68 Deering St., BP#2014-02509

remaining questions:

FIRST FLOOR
68 DEERING ST

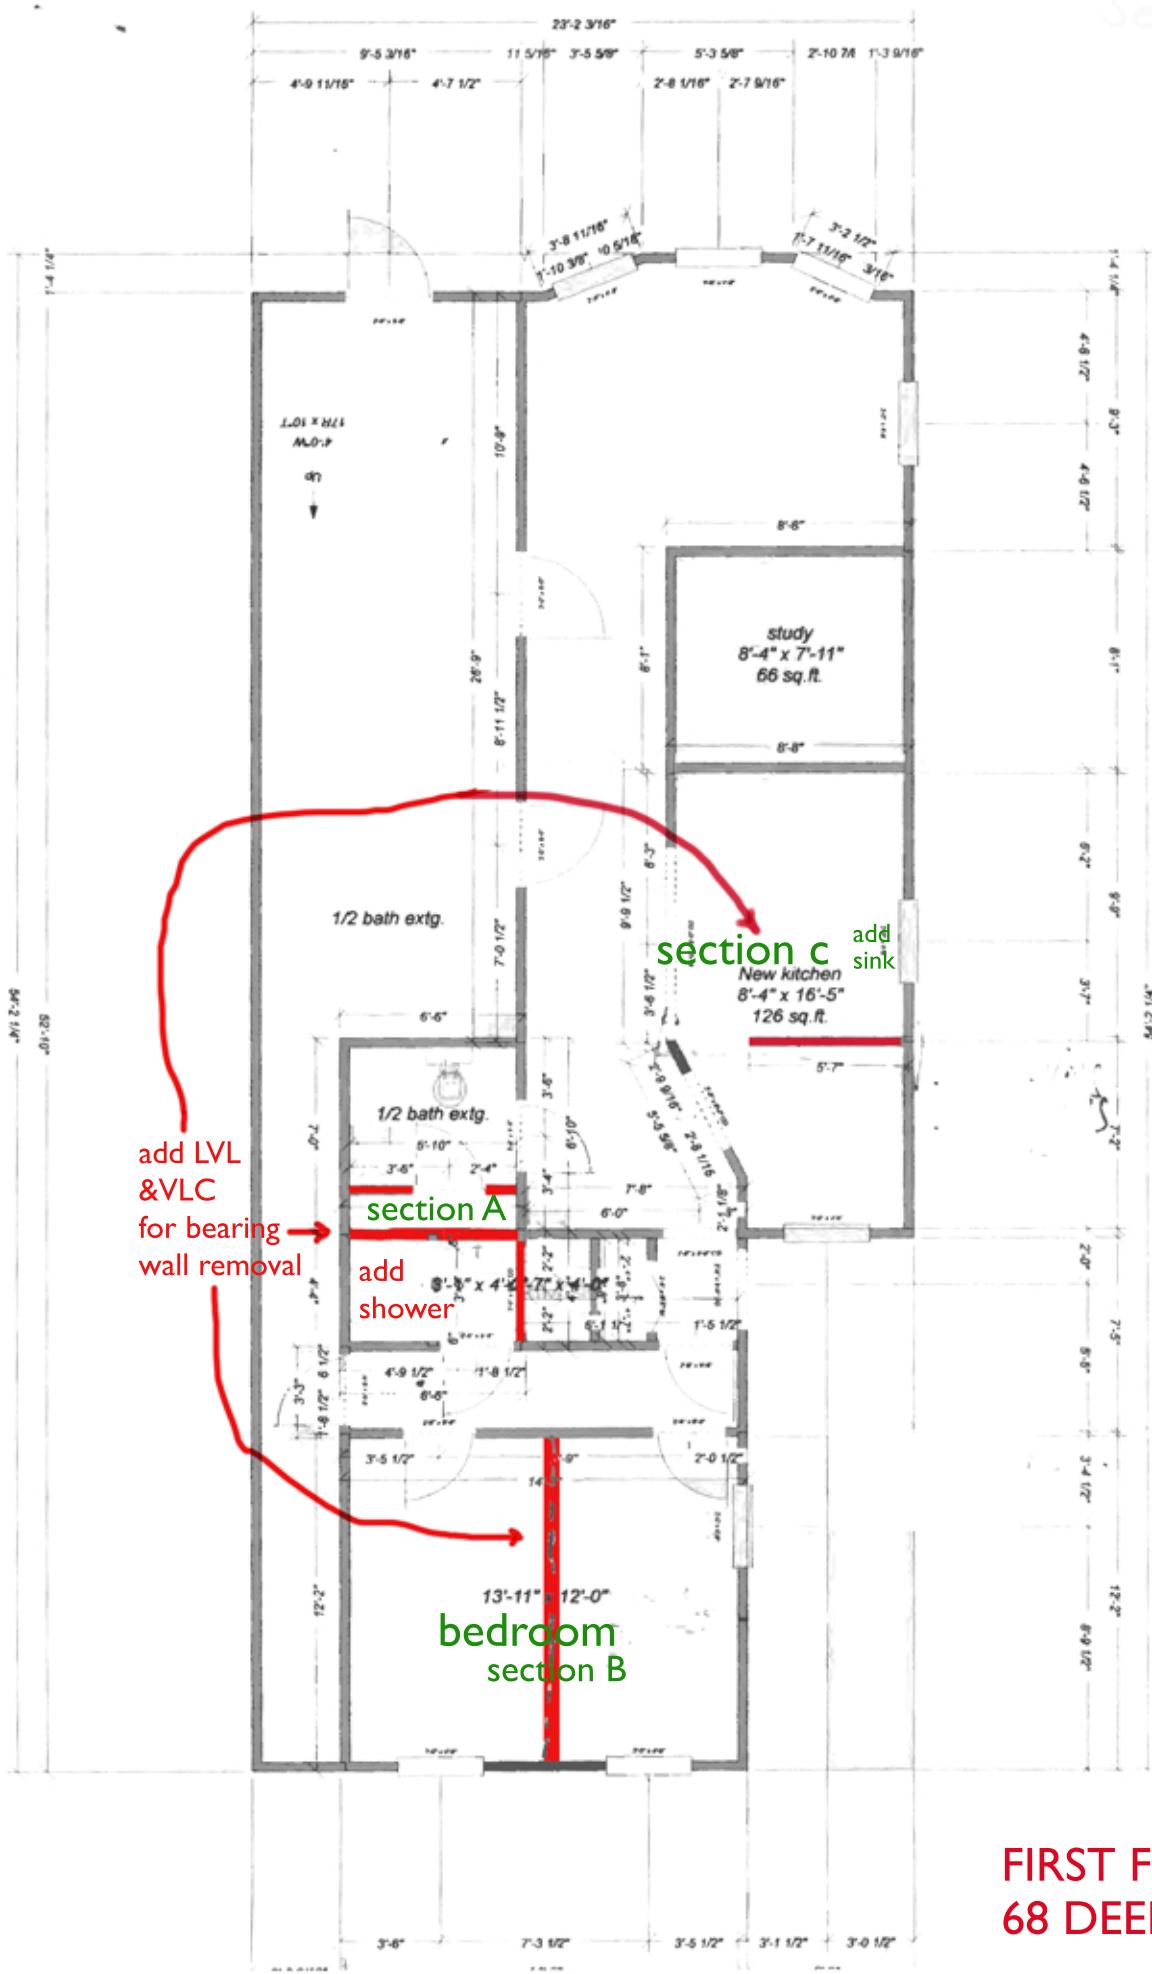
-Diagram of the load bearing path at all new Engineered beams, including any new footings and columns in the basement

-Provide the engineered lumber specifications sheets for this specific job

-Provide the wall infill details, ie. a section or plan view of materials

Steel I-beam for 40" span in bathroom to solid brick wall. I beam carries the upper load with force paths going into the brick supporting the beam. The beam is supported by 6" of brick on either side.

Only steel I-beam.

On the first floor, **only the wall in the bathroom is weight bearing.**

Infill is paper faced 2x6" r=19 pink fiberglass. The paper face will be stapled to the framing lumber.
